**KIRKLEES METROPOLITAN COUNCIL
INVESTMENT & REGENERATION SERVICE**

DELEGATED DECISION TO DETERMINE PLANNING APPLICATIONS

Reference No:	2023/62/91633/W
Site Address:	4, Jim Hill, Chain Road, Slaithwaite, Huddersfield, HD7 5TY
Description:	Installation of new gable window (Listed Building)
Recommending Officer:	Sam Jackman

Officer Report – 2023/91633 – planning

DRAWING TITLE  
 PROPOSED PLANS AND ELEVATIONS

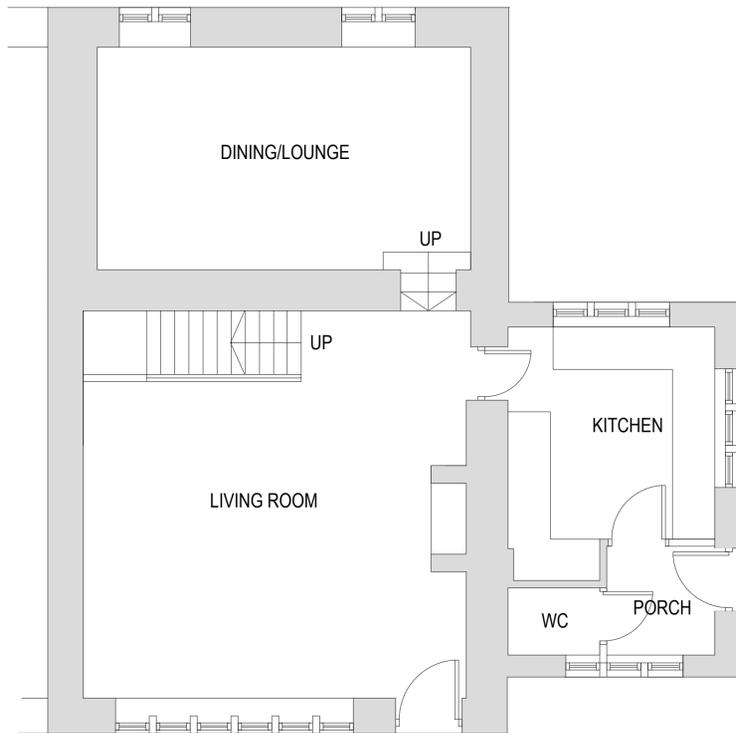
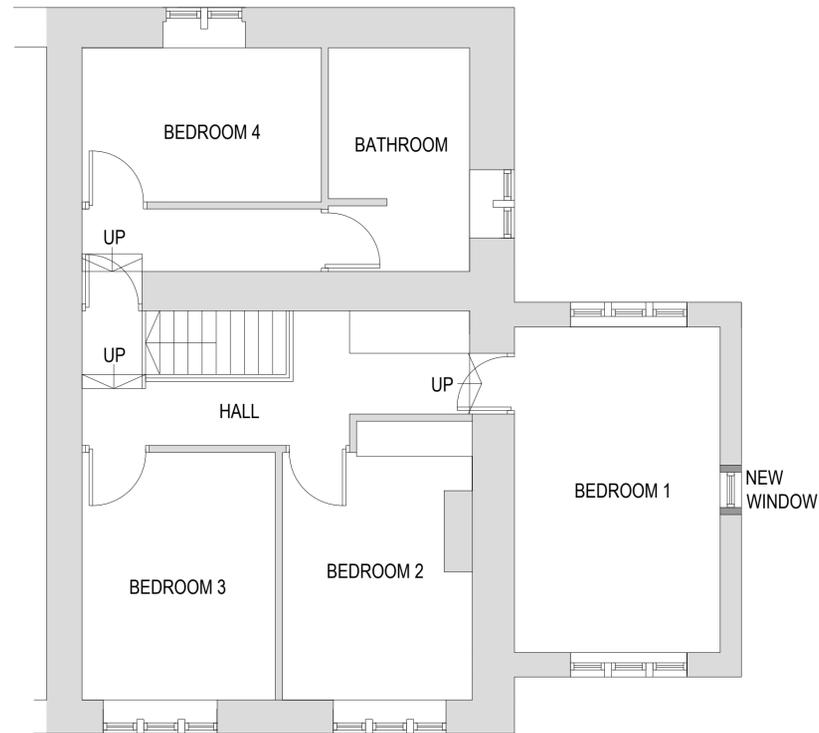
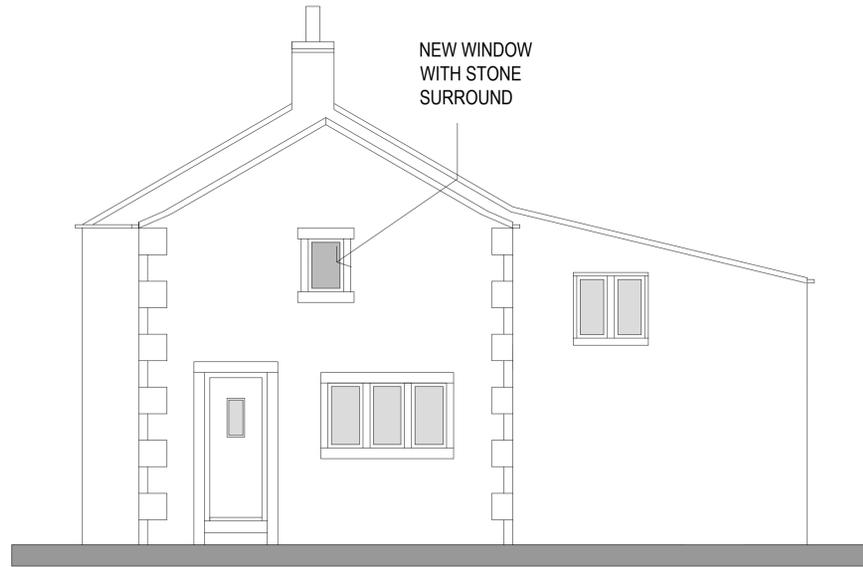
The original plans showed the window to be a round bullseye design, which has been replaced with a small rectangular window.

K.C. Conservation & Design – informal discussion with Listed Building officer who confirmed that the bullet window is not characteristic to a former weaver's cottage nor does the adjacent barn have any circular windows.

The proposed alterations to the building are for the creation of a small non-opening window in the gable of the existing side extension to the host property. Where the window has been amended from a round window to a rectangular one, reflect the style of the cottage.
